Consultee Comment for planning application 22/02757/DISC

### Mitigation & Enhancement Plan

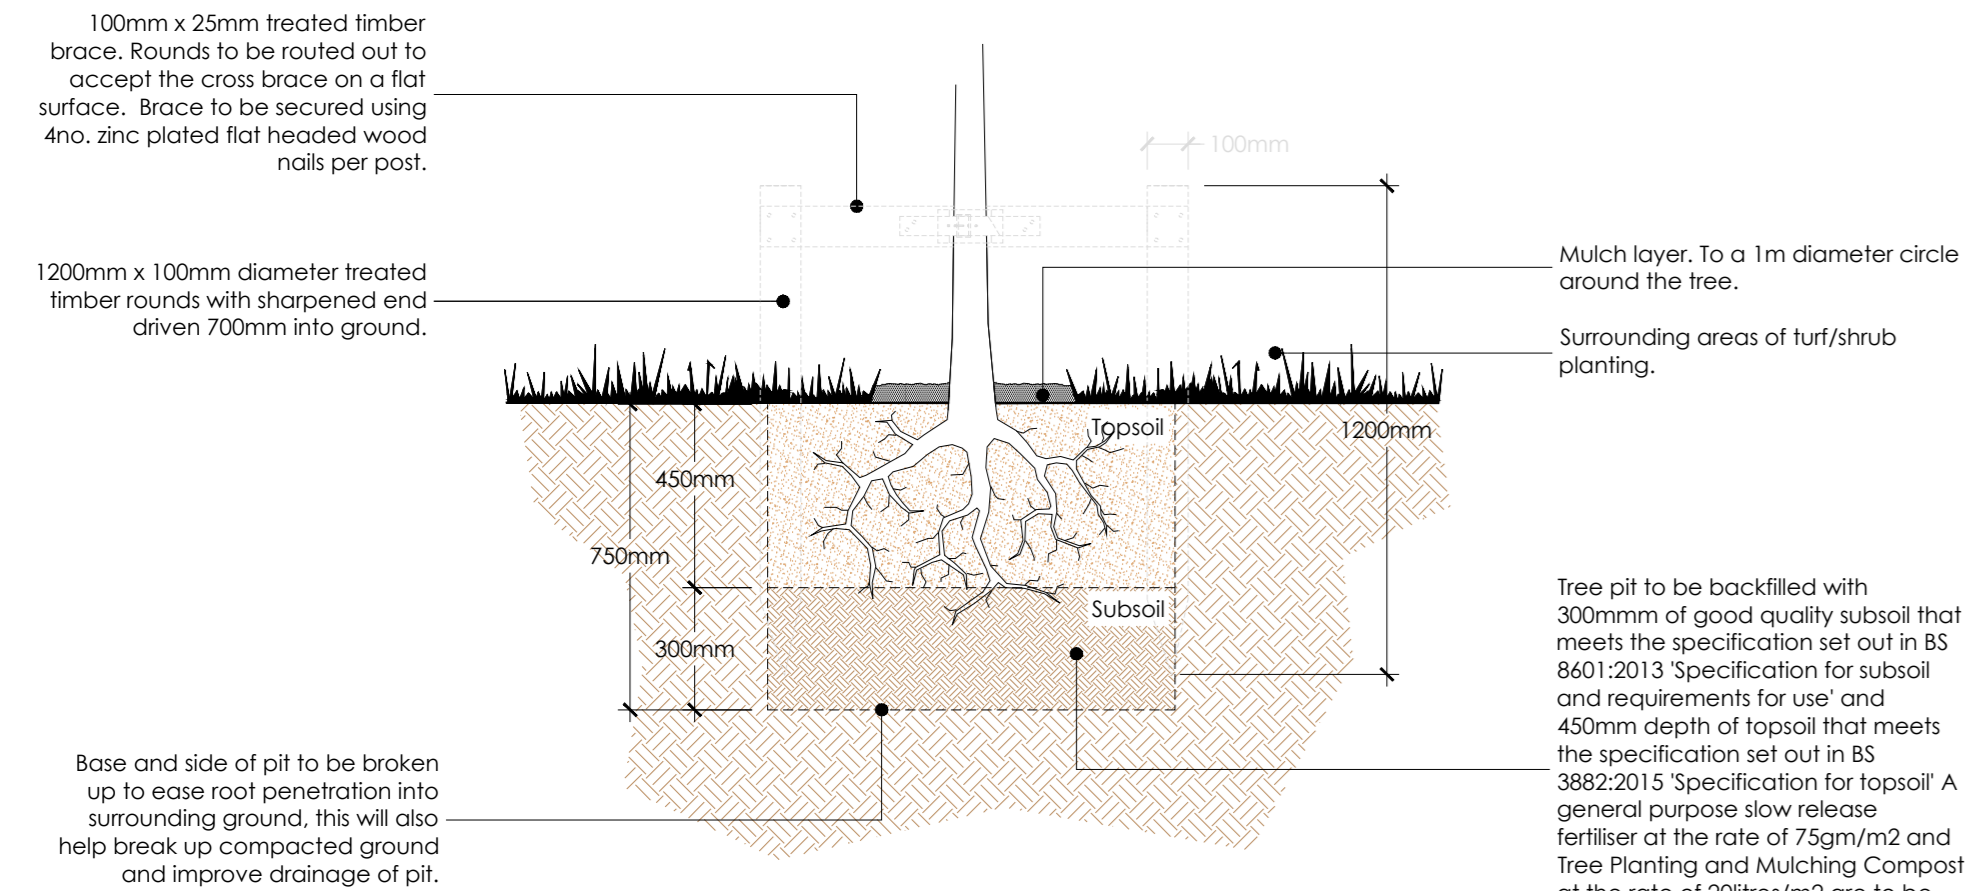
provisions are required here. I would recommend that at least some of these are swift bricks
are these are used by other species also.
I think the document needs to go further therefore before it fulfils the conditions.
Kind regards
Charlotte
